Yorkshire and North East Area

Date: 13th March 2026

Ref: 2025/60/93572/E - Outline application with all matters reserved, bar vehicle access into the site, for erection of up to 123 dwellings with associated works including open space, landscaping, drainage infrastructure.

site area 5.53ha / 13.67 acres
 capacity 123 dwellings
 density 22 dwellings / ha
 9 dwellings / acre

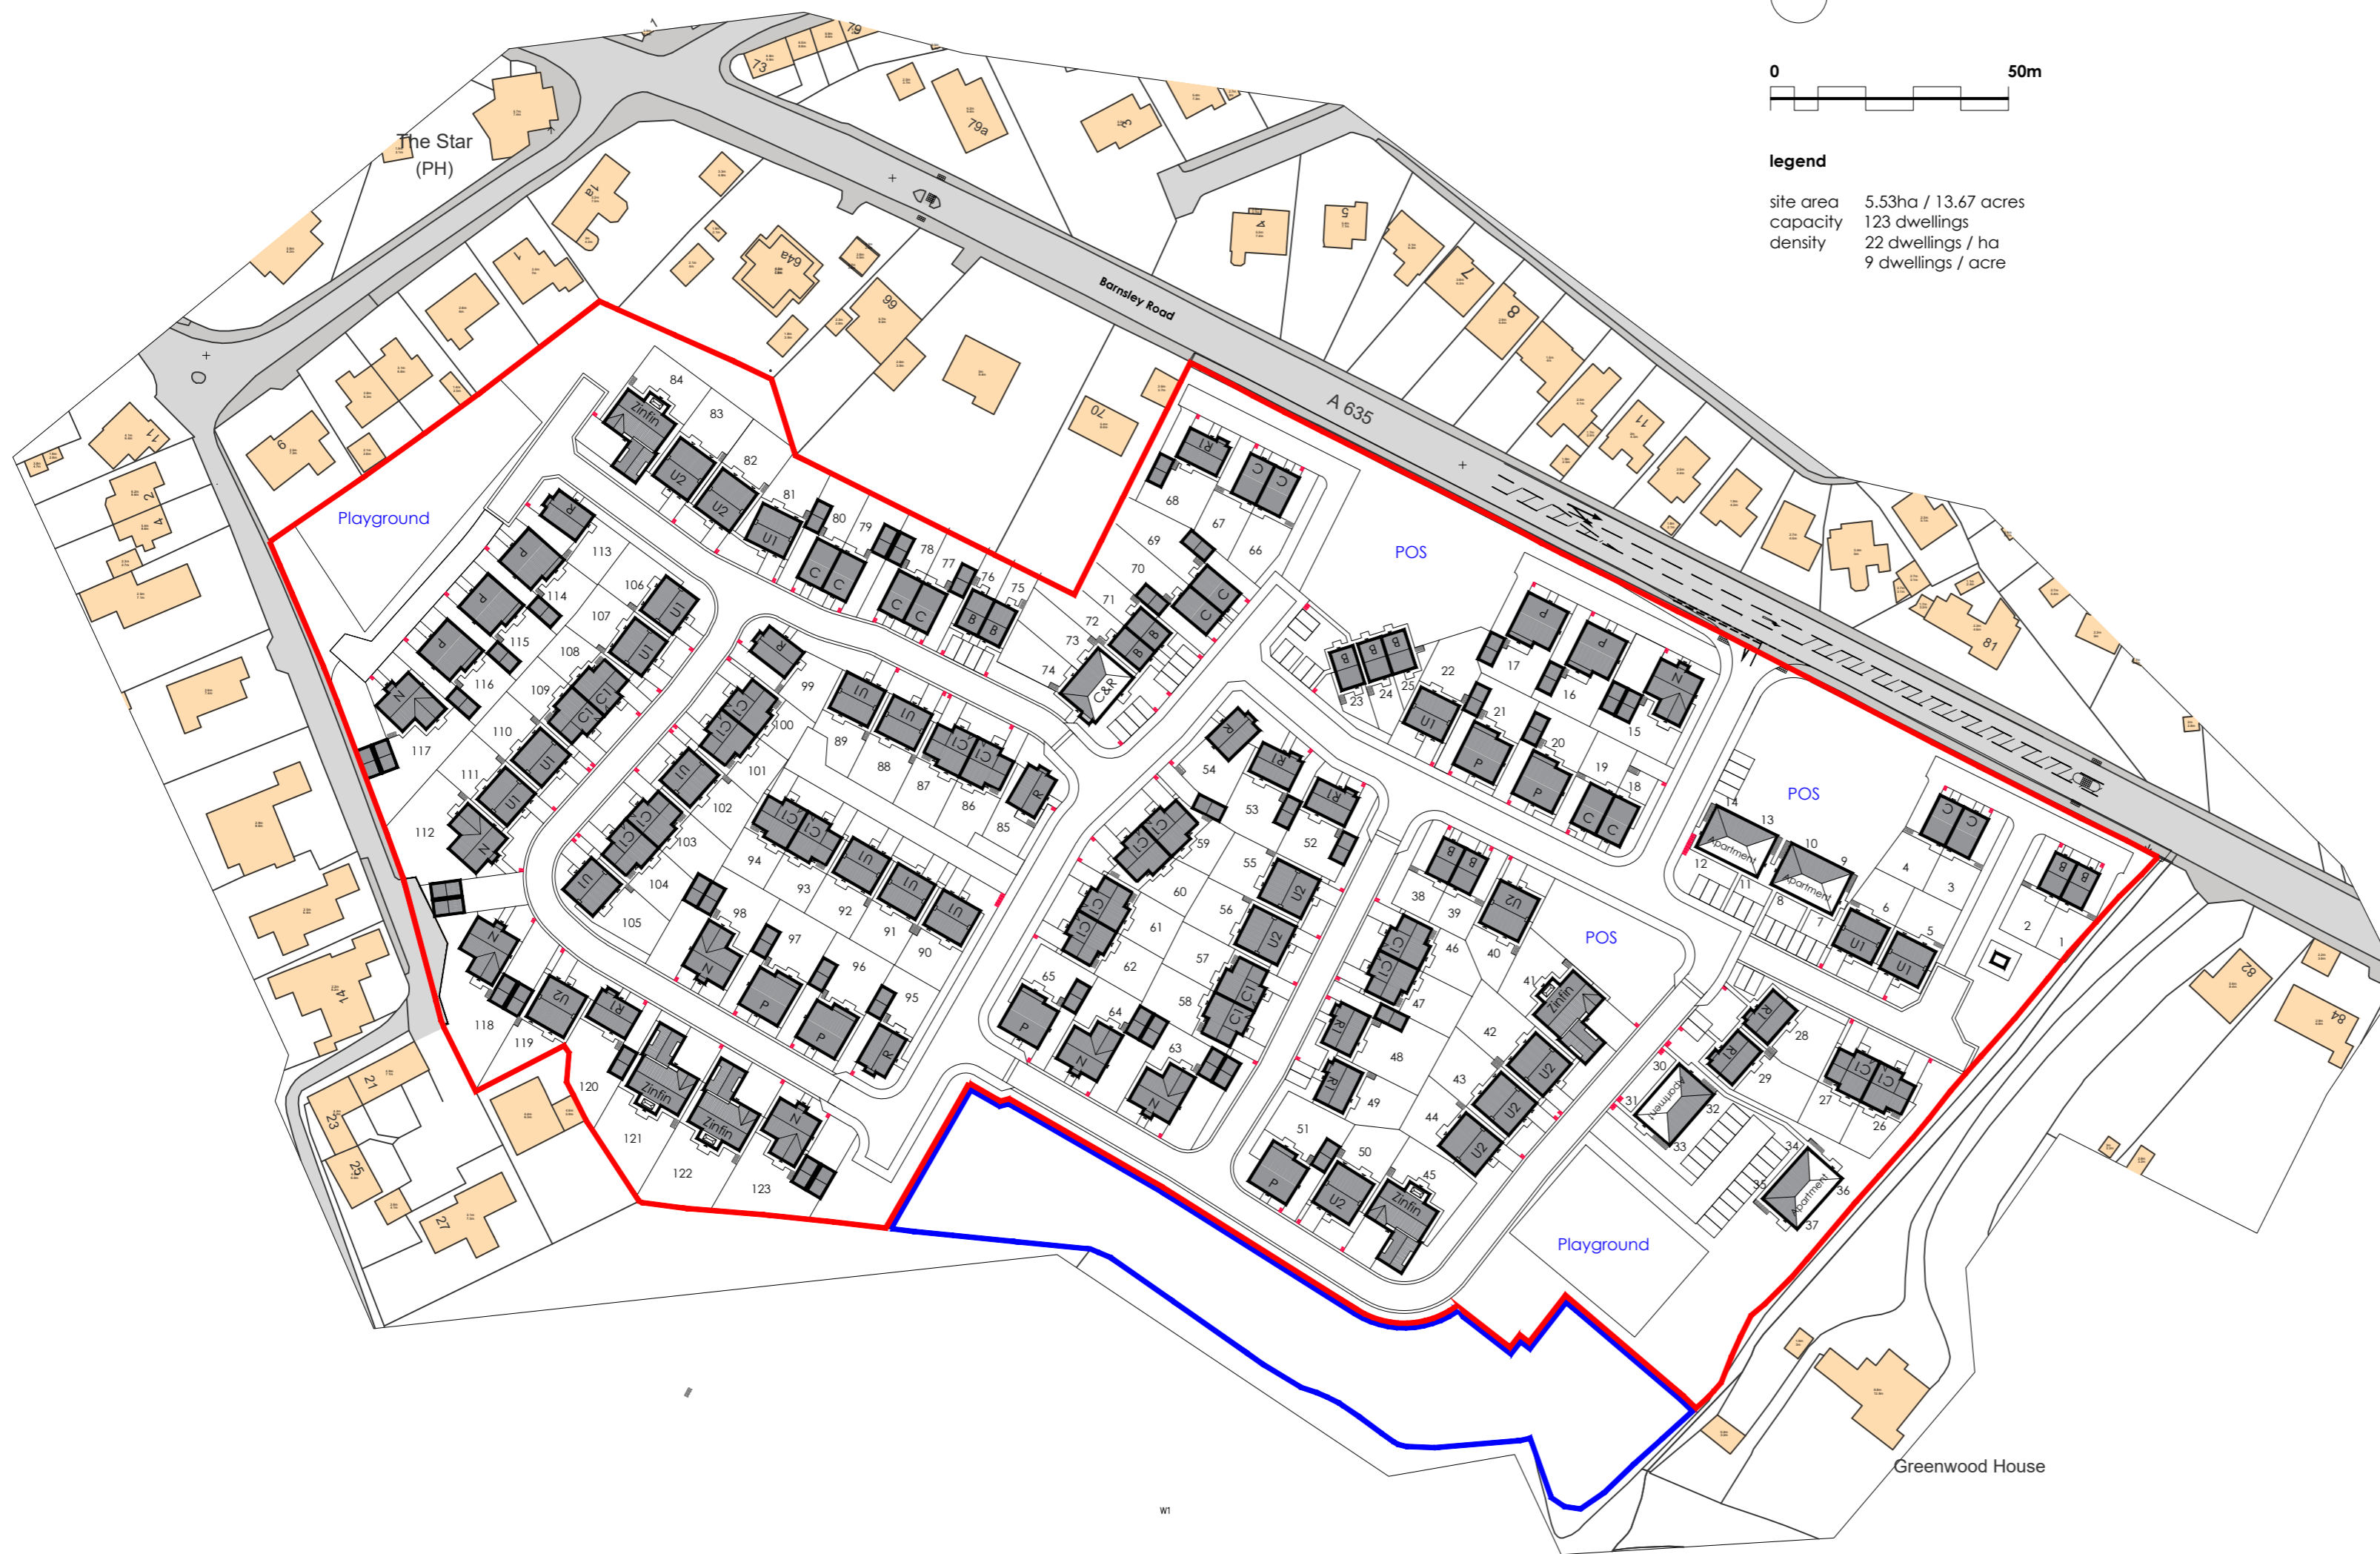
Although the Forestry Commission was not consulted about this application, it came to the attention of the Yorkshire and North East area team. A Forestry Commission Woodland Officer is familiar with the site and is of the opinion that the 15m buffer proposed for the ancient woodland identified in the application, is not sufficient to prevent deterioration of this irreplaceable habitat. There are also no wholly exceptional reasons in support of the application.

Because it is not possible to compensate for the loss or deterioration of ancient woodland, we would support efforts to ensure the protection of the ancient woodland identified in the application. The most effective way to protect ancient woodlands from harm caused by development is to provide buffer zones which ensure that none of the detrimental impacts of

the development, extend to the woodland. Please refer to the Natural England and Forestry Commission standing advice for more information about buffer zones.
